Application no: 22/02407/DISC

Location: Jacobs Douwe Edberts (JDE) Ruscote Avenue Banbury

Transport Development Control

Condition 6:

Access/ Egress and Security

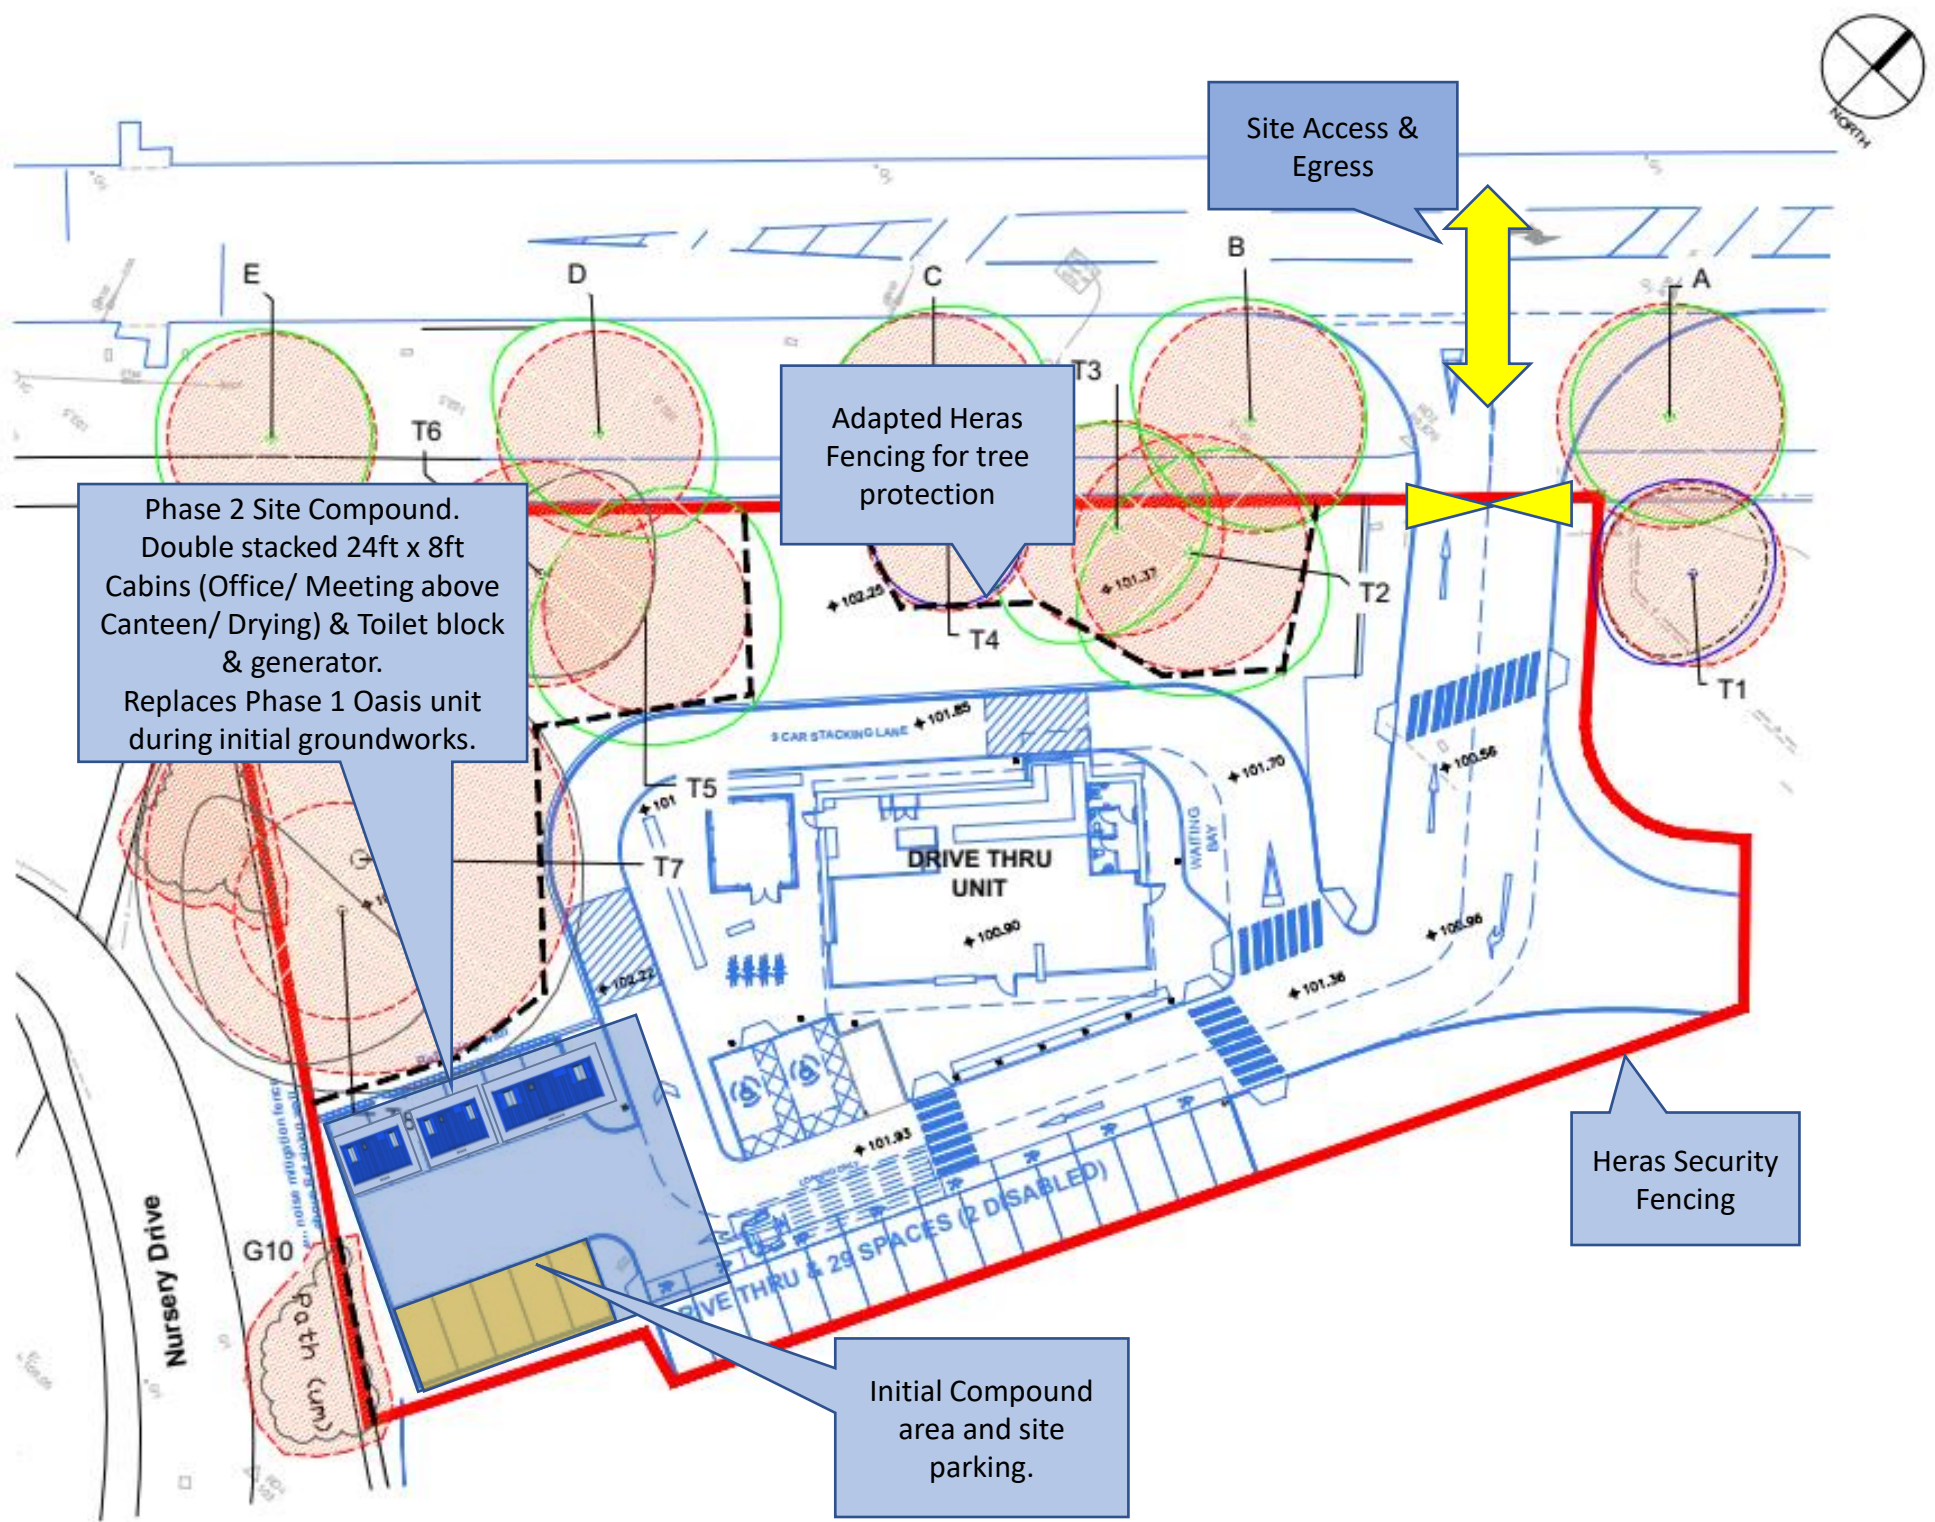
Travel Arrangements noted but can the CTMP be updated to show the maps of construction vehicles on a map a request previously.

No temporary access arrangements noted, can CTMP be updated to show this.
